Your Ref: BR/340/17/DOC

12 March 2018

Town & Country Planning Act 1990 (as amended)
Town and Country Planning (Development Management Procedure) (England) Order 2015
Application for approval of details reserved by condition imposed under planning permission
BR/108/16/PL relating to condition No. 3 (Schedule of materials & finishes to be used for the
external walls & roofs of the proposed extensions/alterations) & condition No. 5 (covered & secure
cycle parking spaces)
19 High Street Bognor Regis,,

GROUND FLOOR 1:50 @ A1

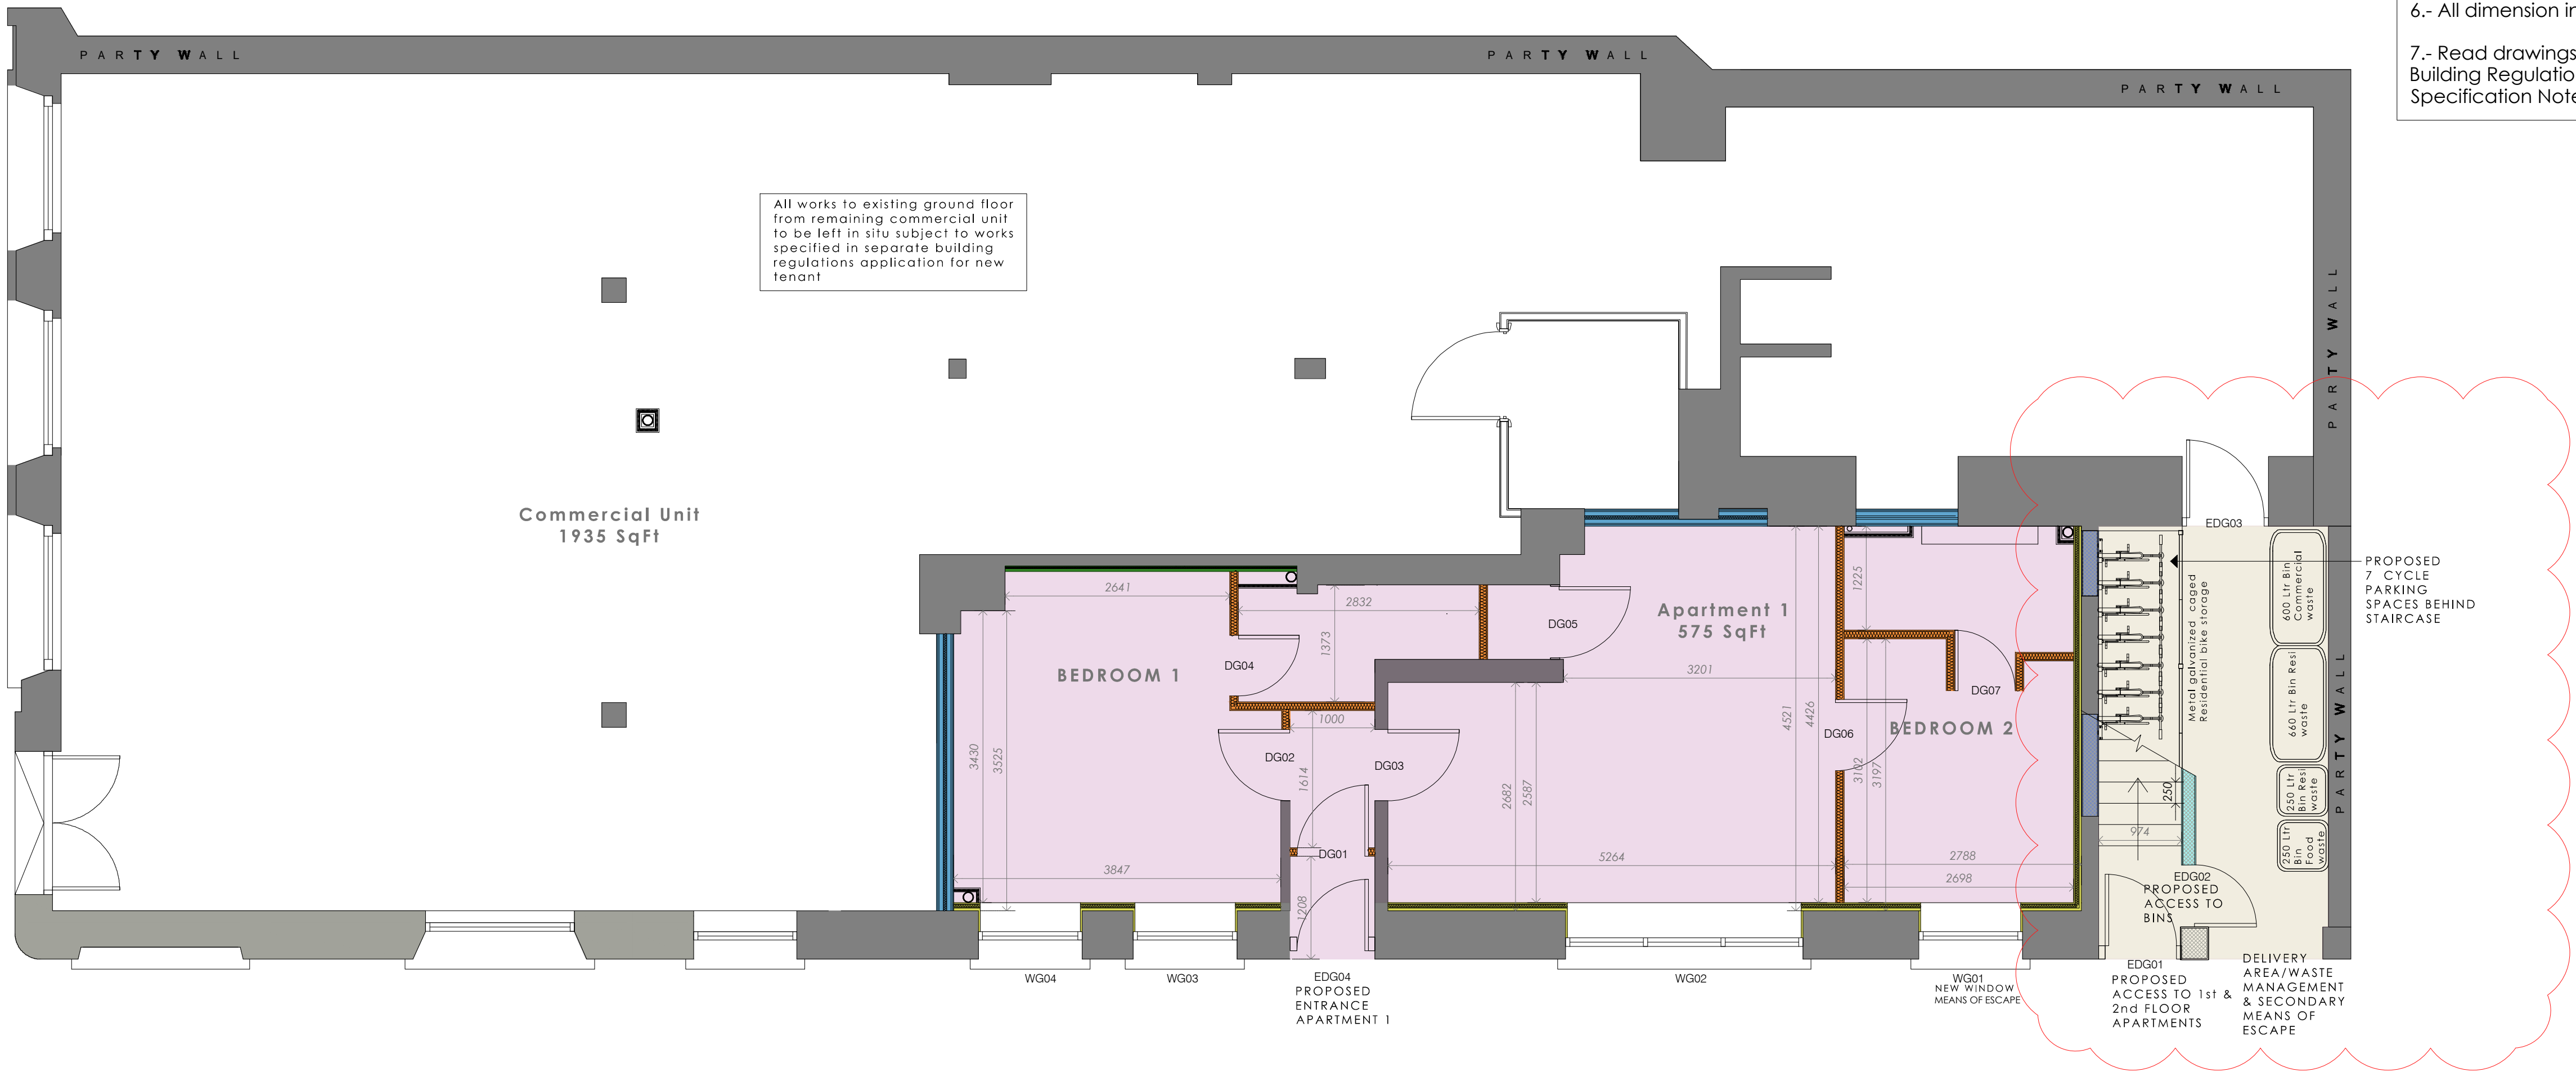
The submitted details in respect of secure cycle storage namely the communal metal galvanized residential bike storage cages as shown on Drawing BR-264-05 (14/12/17) are considered to provide an acceptable scheme and satisfy the requirements of the condition.
